**Our Ref: FP/114/11/CA**  
**Your Ref:**

**Please ask for:**  
Mrs S Honney-Bayes  
01903 737500 Ext 37445  
14th June 2011

**Application for conservation area consent for demolition of existing dwelling & outbuildings & erection of 6 no. apartments with associated parking & landscaping (re-submission following FP/183/10/CA)**  
**30 Limmer Lane Felpham Bognor Regis**

Dwg. No.
030510/SL-30 C

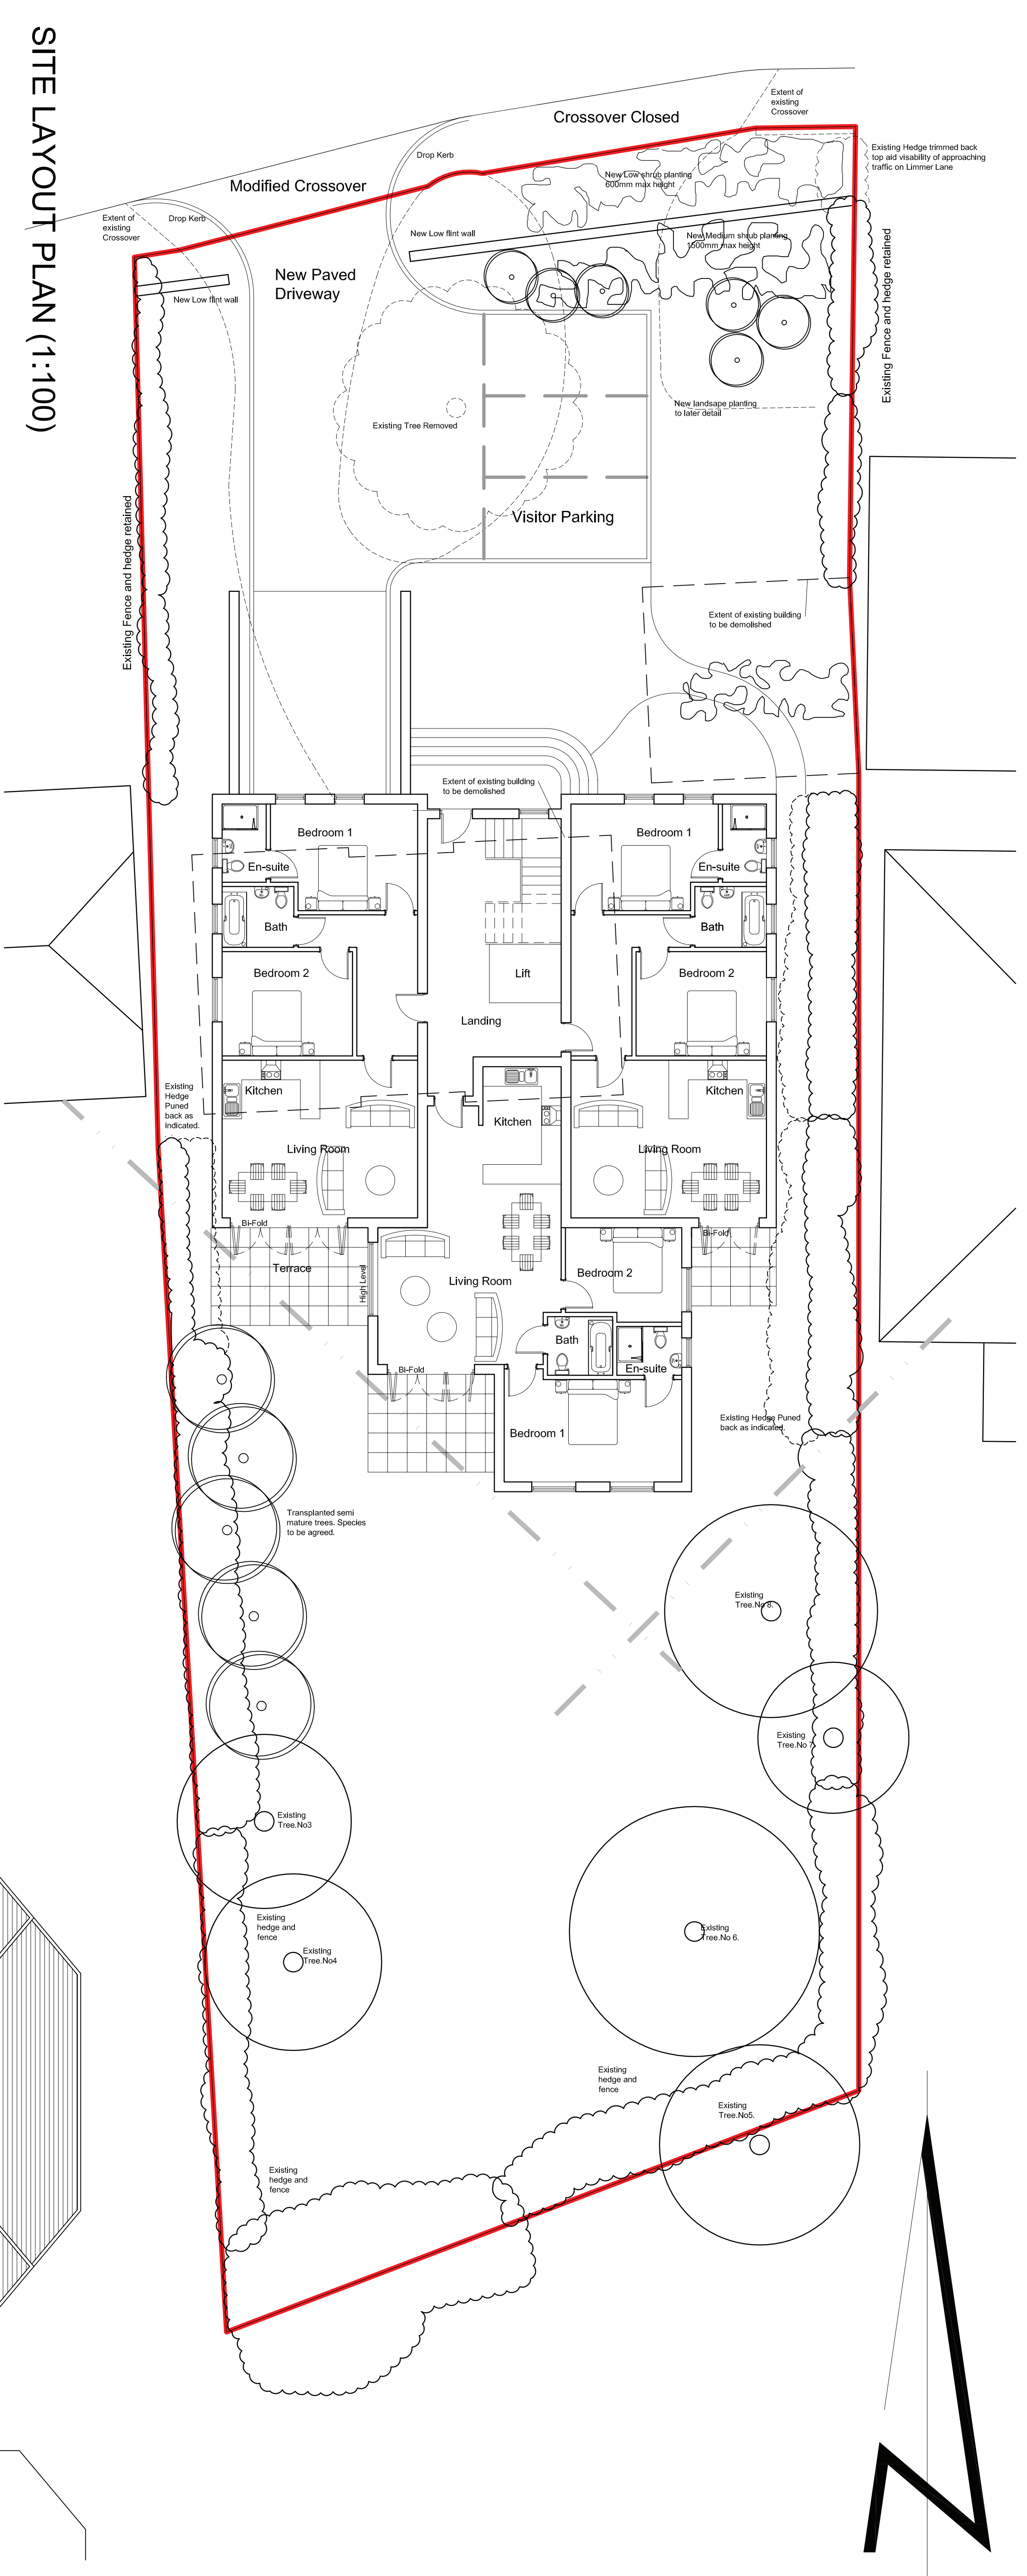
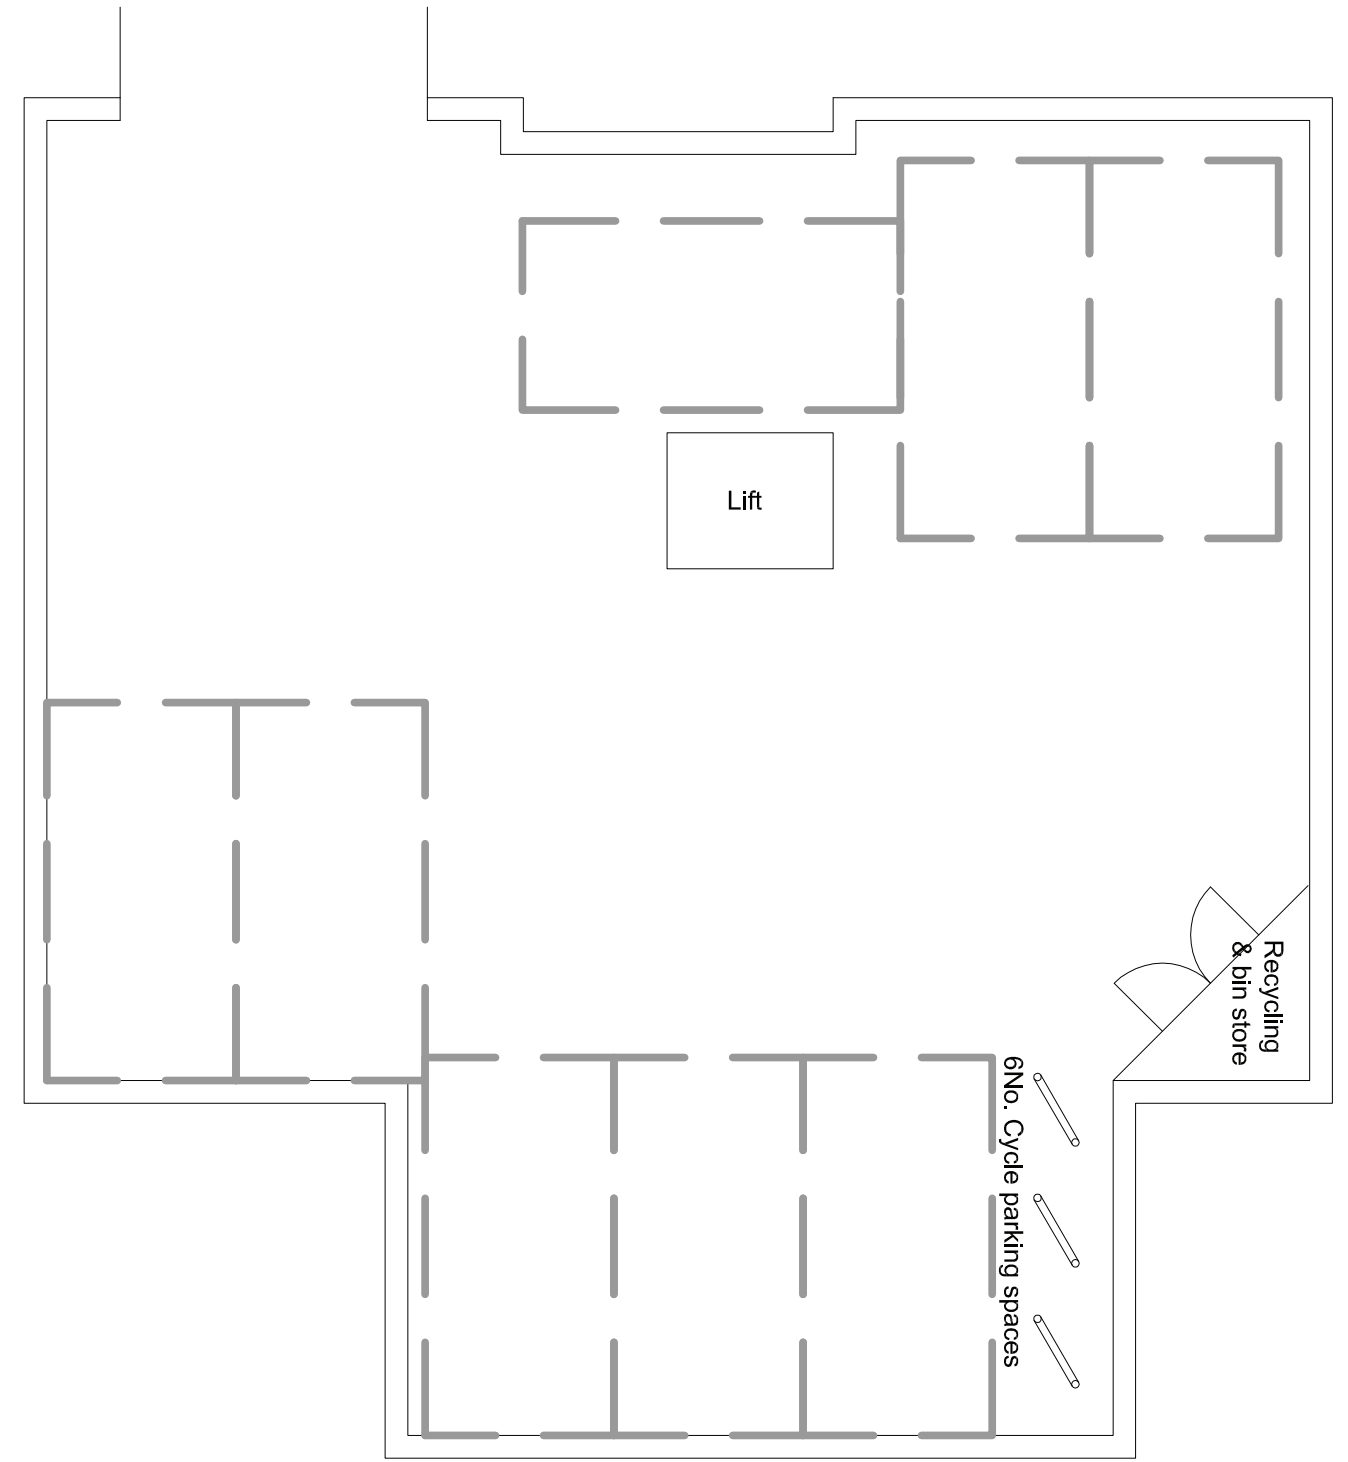
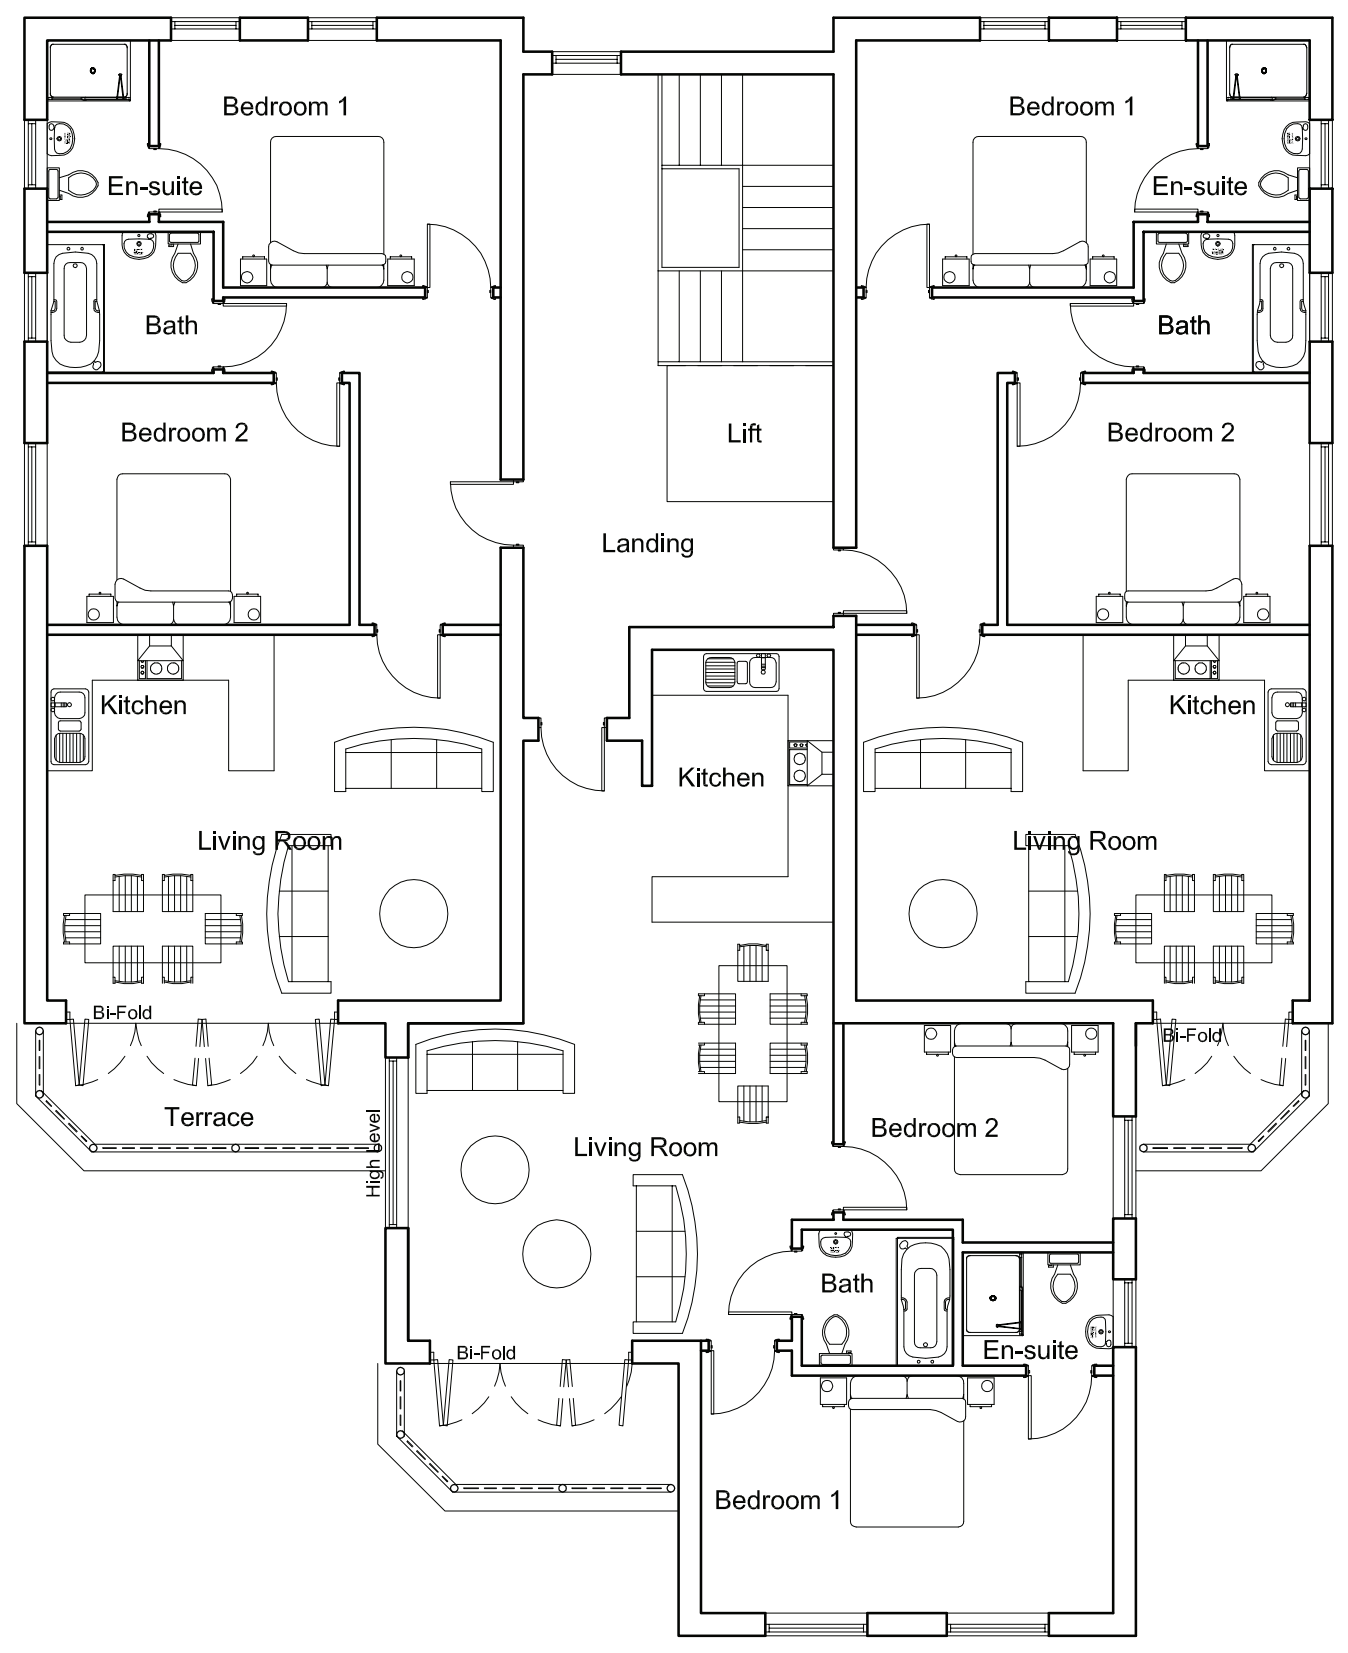
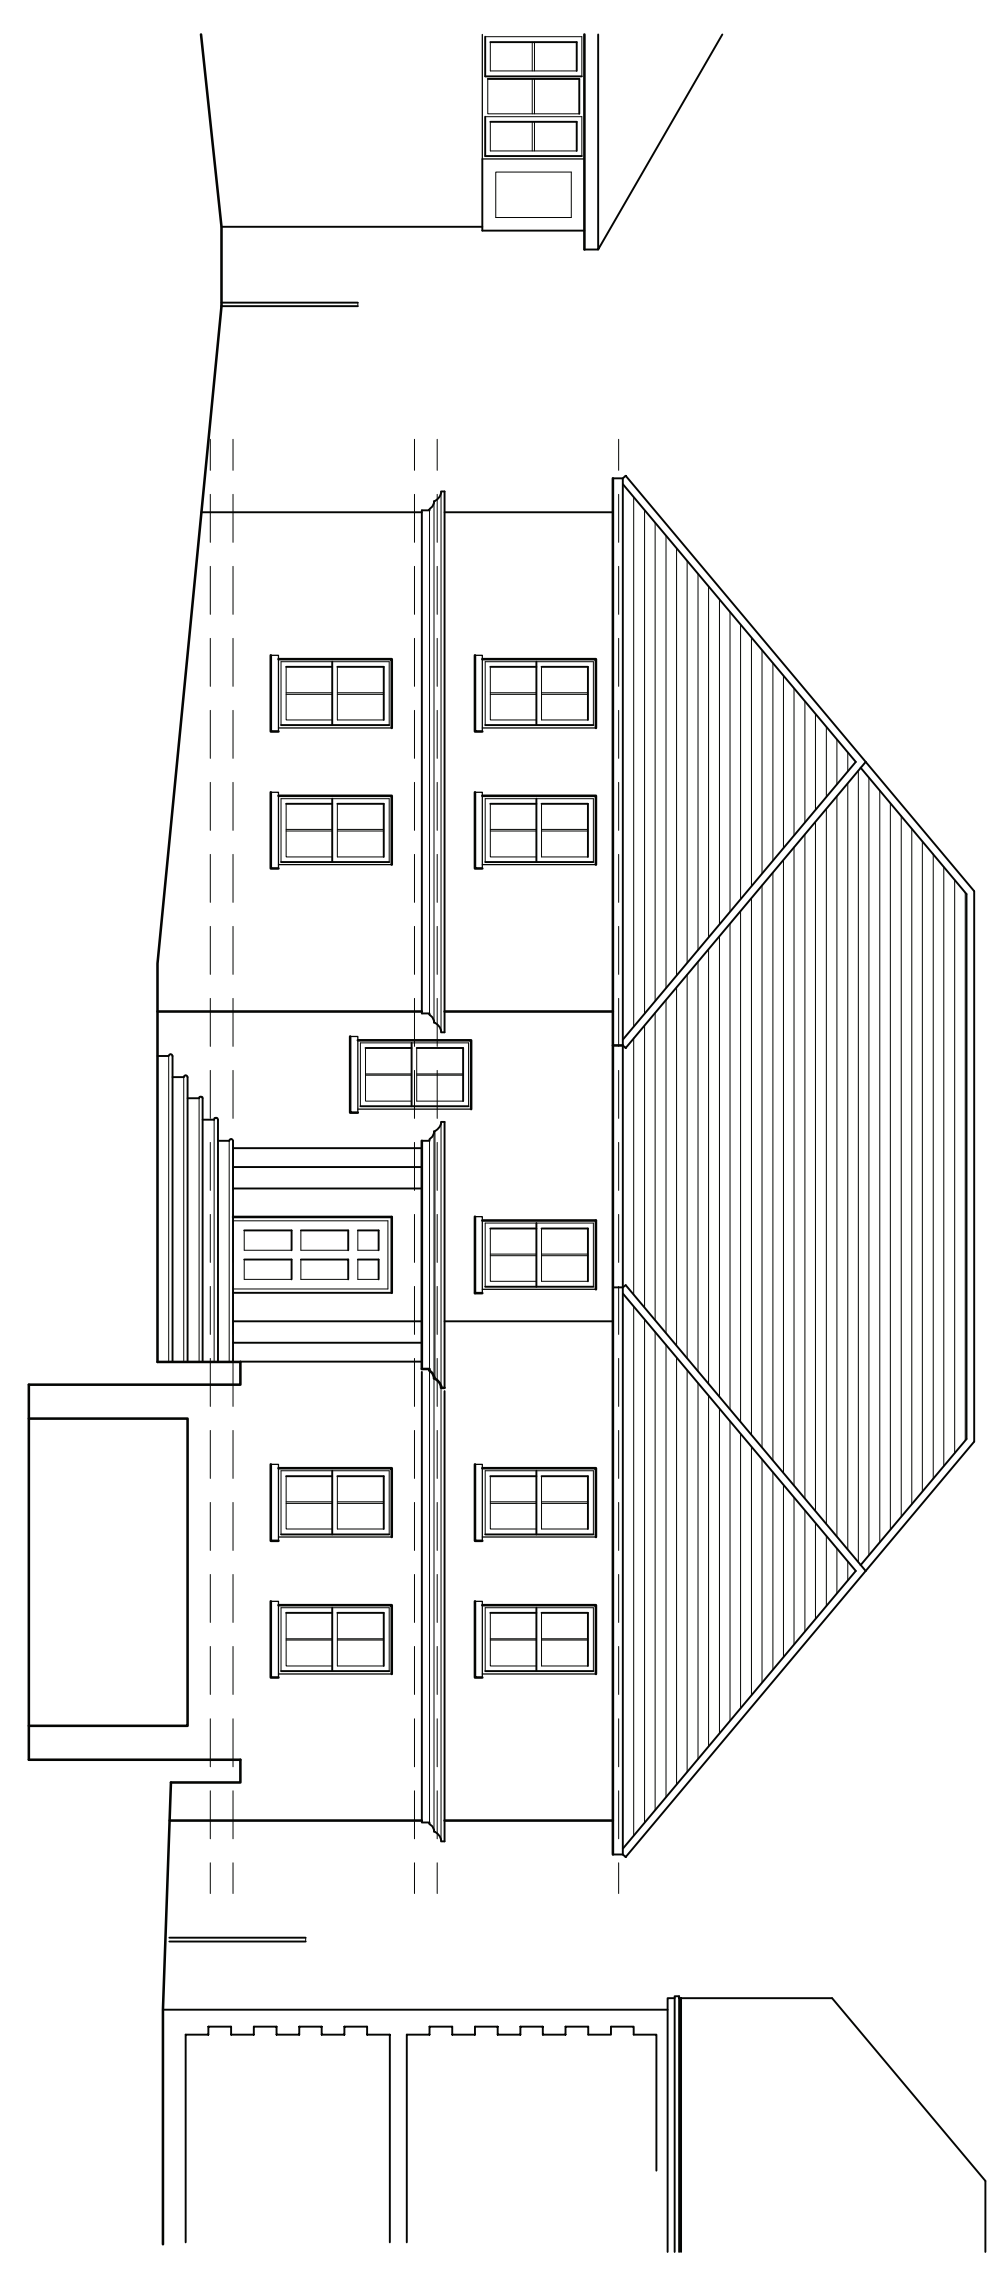
I require 1 electronic or 3 paper copies of a revised existing block/site plan showing a red edge around the application site, and a revised proposed block/site plan showing the 6 cycle spaces, in accordance with the guidance notes available on our website detailed below (click on National List).

There are 11 car park spaces detailed on the application form, however the plans only show 10. Please amend.
